**WEST SUSSEX COUNTY COUNCIL
STRATEGIC PLANNING CONSULTATION**

SUBJECT: LU/32/12/DOC - Application for approval of details reserved by condition 5 & 6 of previously approved LU/350/11.

Millfield Rest Home, 9, St Catherines Road, Littlehampton, West Sussex, BN17 6HS

Proposed parking for cycles AND MOTOR VEHICLES

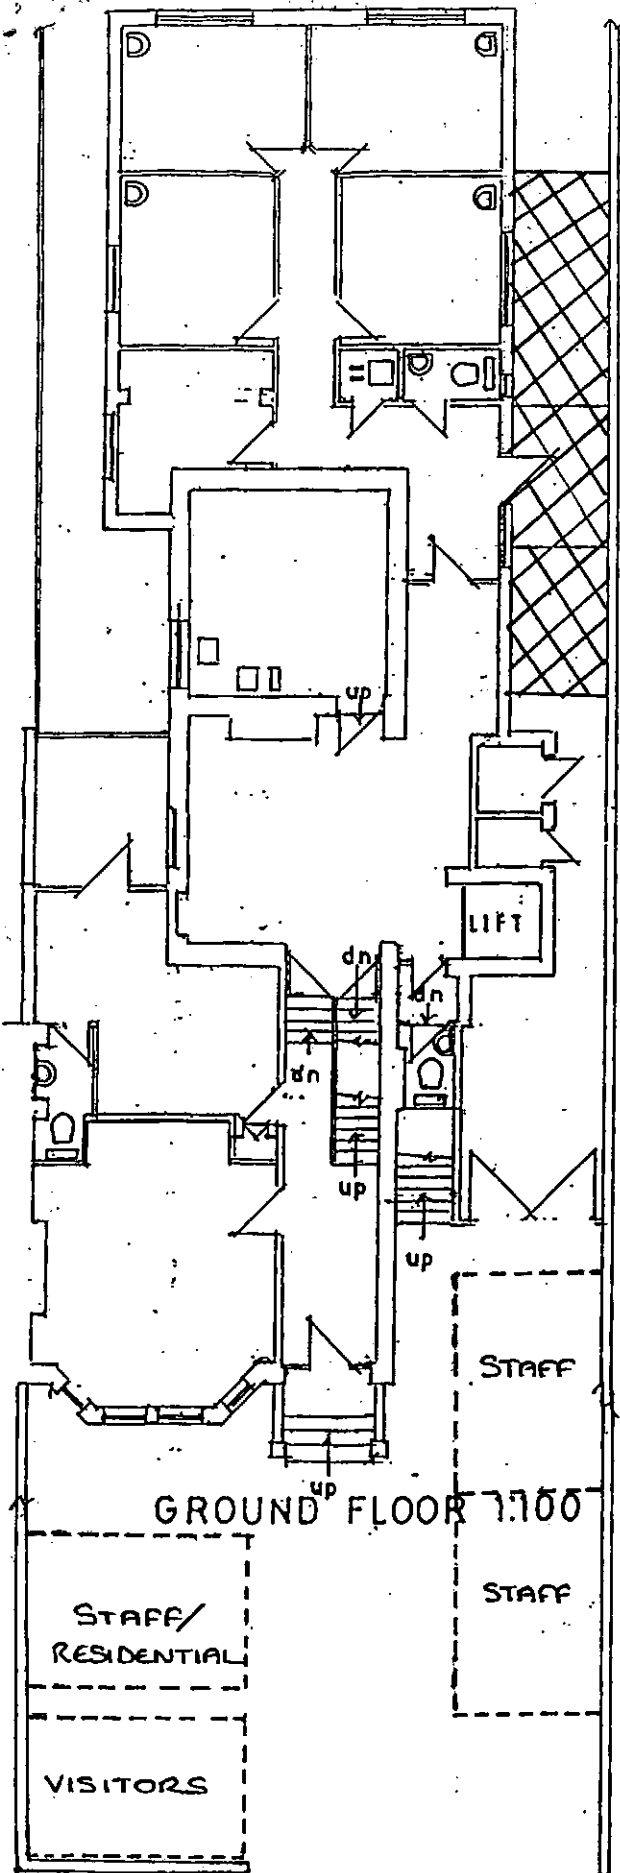
The applicant has supplied a plan and photographic evidence identifying a covered space within the curtilage of the property that can be used for cycle parking. It would appear that this area is secured by gates at both the front and rear access to the property. Current WSCC cycle parking standards would require enough space to store four cycles (two each for the residential and office elements of this development), and from measuring the plans provided the area is considered to be an appropriate size.

The applicant has supplied a plan and photographic evidence detailing the proposed parking layout, which allows for four spaces (1 x Visitor, 1 x Residential / Staff, 2 x Staff). I can confirm that the quantity of parking spaces is inline with current WSCC parking standards for a development mix of this type in this location. From inspection of the plan provided the proposed parking layout would not appear to be ideal as the layout could result in vehicles having to be moved to allow others to exit the site. However the site does benefit from a wide open access with good vehicular and pedestrian visibility so this manoeuvring would not be considered detrimental to highway safety. The applicant may wish to consider the removal of one of the 'staff' vehicular parking spaces to allow for more convenient manoeuvring on site, I can confirm that providing three vehicular parking spaces for this development would also be considered appropriate. I would highlight that the removal of one on site car parking space may increase the demand of on-street parking. The allocation of the parking spaces also appears to be appropriate.

From the information I have before me there would be no highway concerns raised from the discharge of conditions 5 and 6 of planning approval LU/350/11.
